**Subject:** R-6 Small Infill Design Review – 5 Merrill Street

**Written by:** Caitlin Cameron, Urban Designer

**Date of Review:** Thursday, December 8, 2016

ROOF PLAN  
Scale: 1/4" = 1'-0"

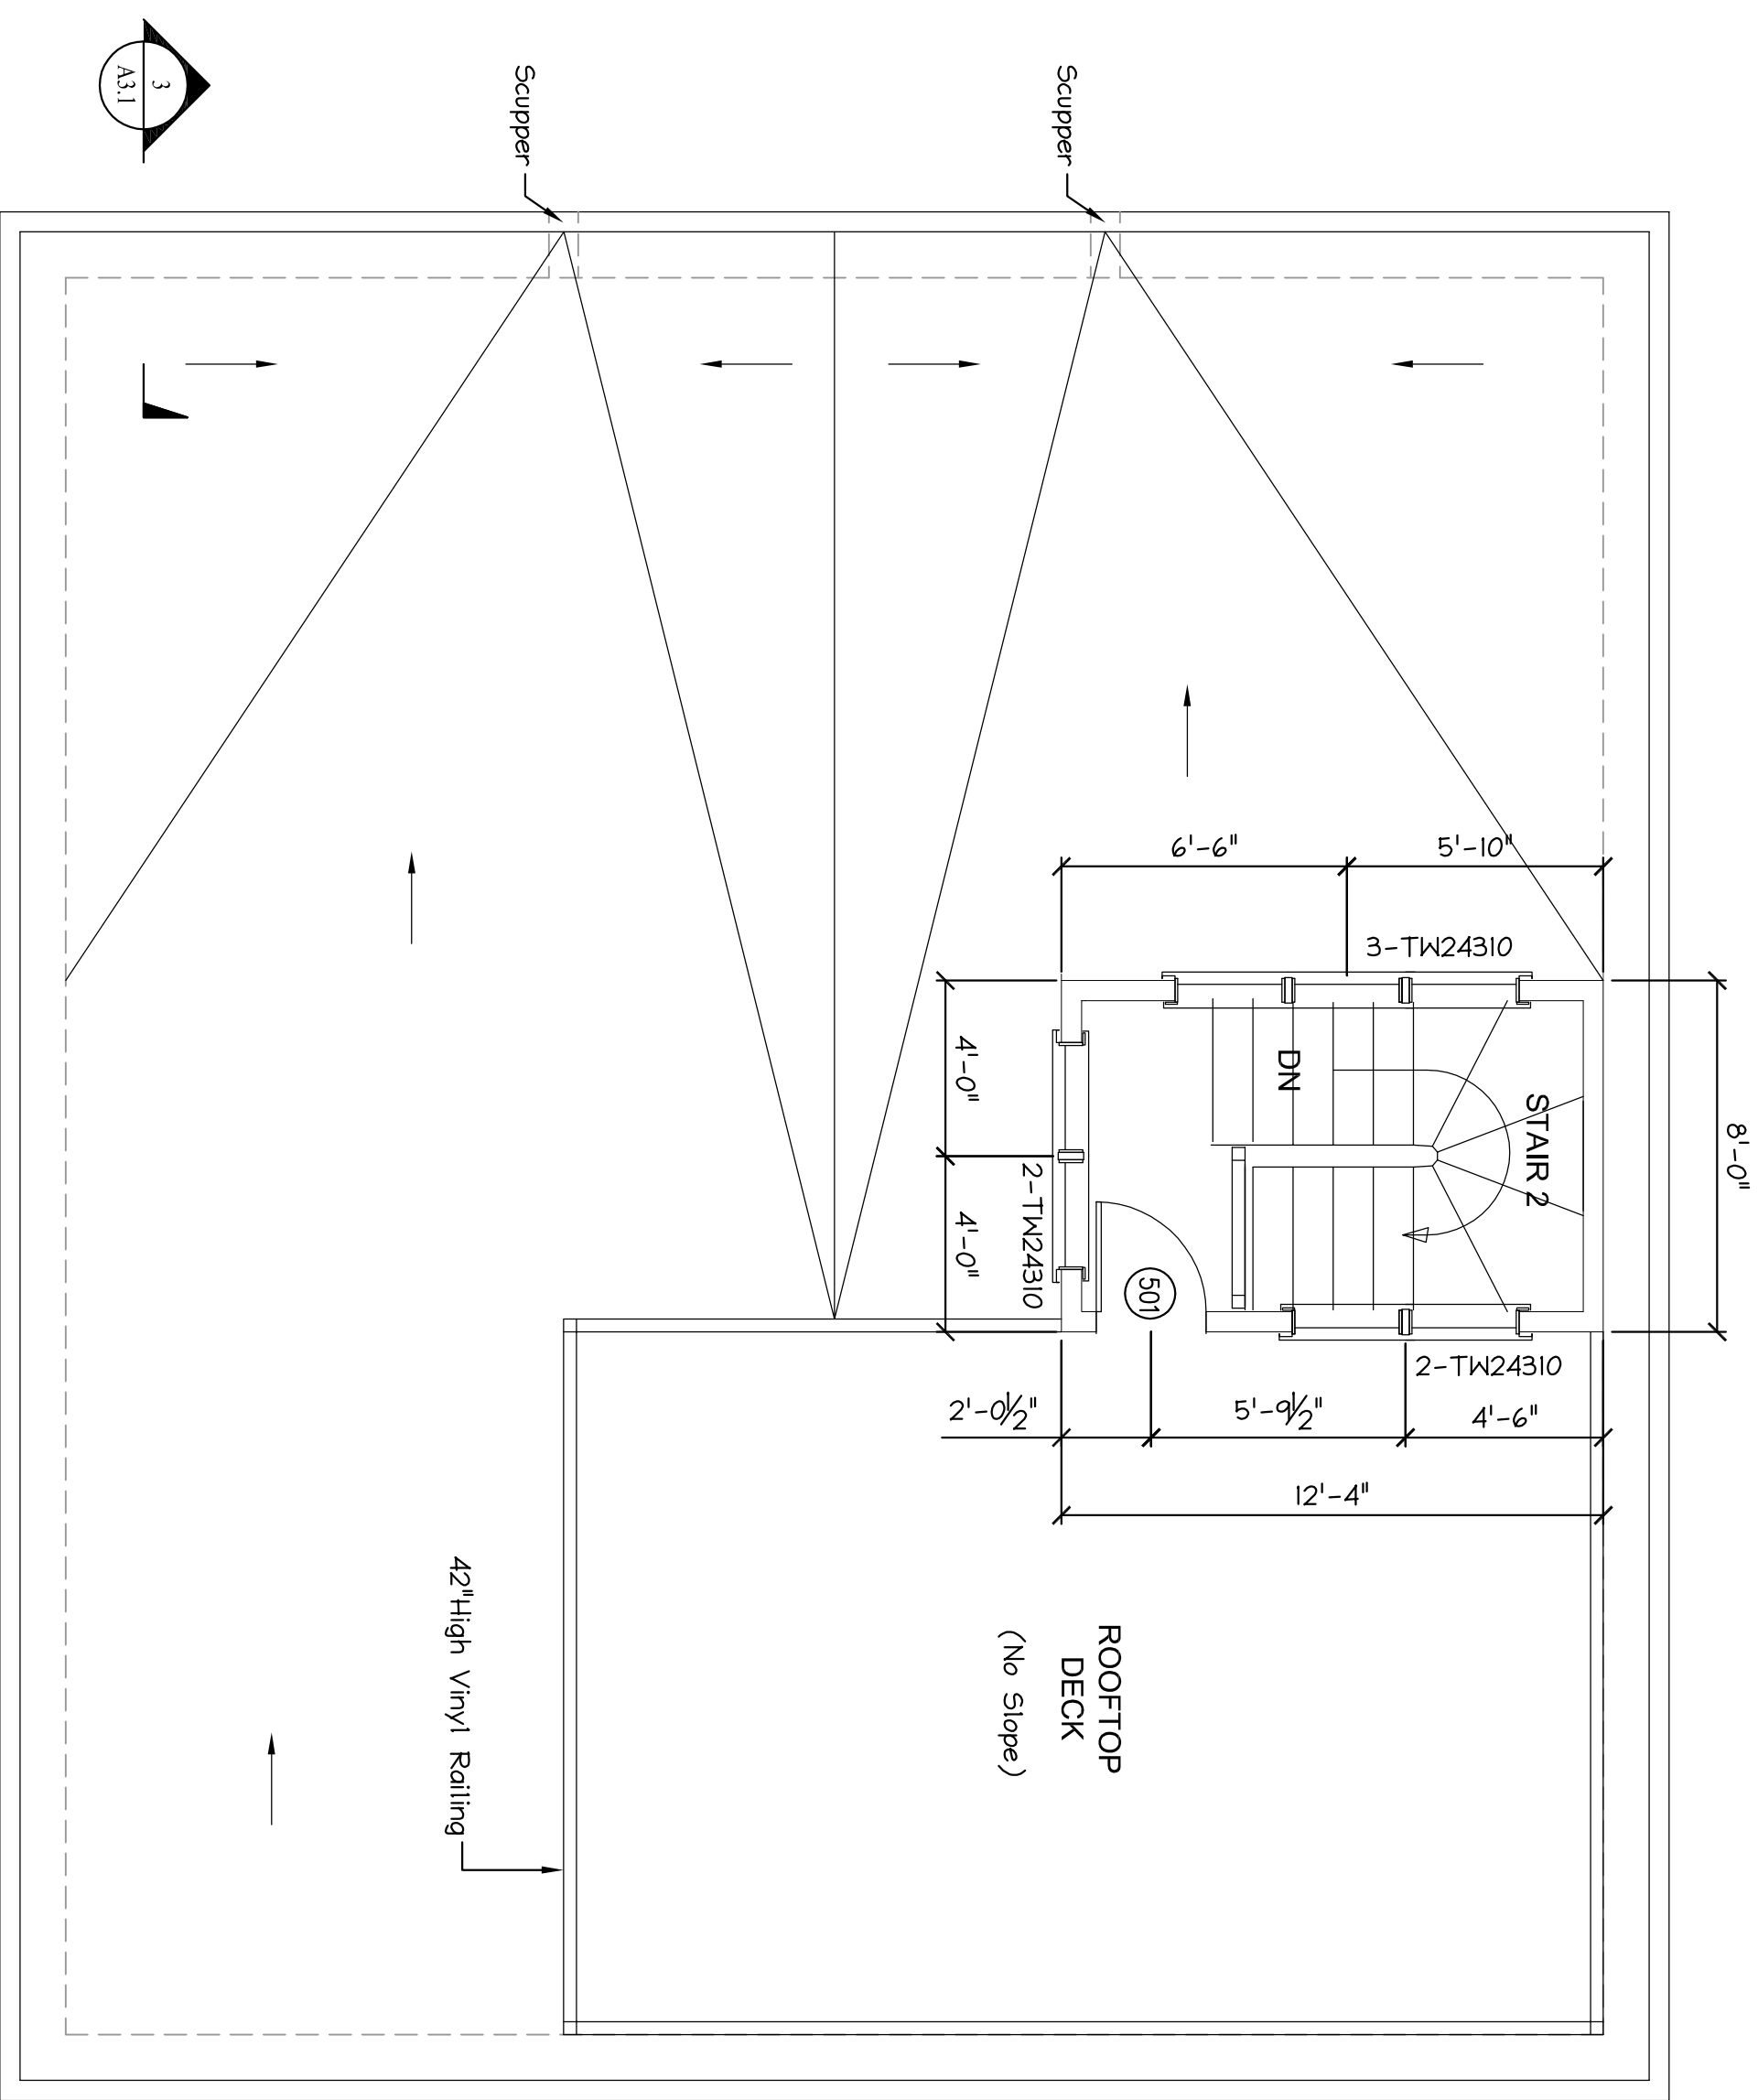
- *B-2 Roof Forms:* The proposed project has a flat roof at the 4<sup>th</sup> floor. **This does not appear to meet zoning stepbacks. The fourth floor should become more recessive to meet both the design guidelines and the zoning requirements.**

- *B-3 Main Roofs and Subsidiary Roofs:* There is a main roof form. **However, the stair overrun should be made more recessive – reduce or eliminate the cornice and windows.**
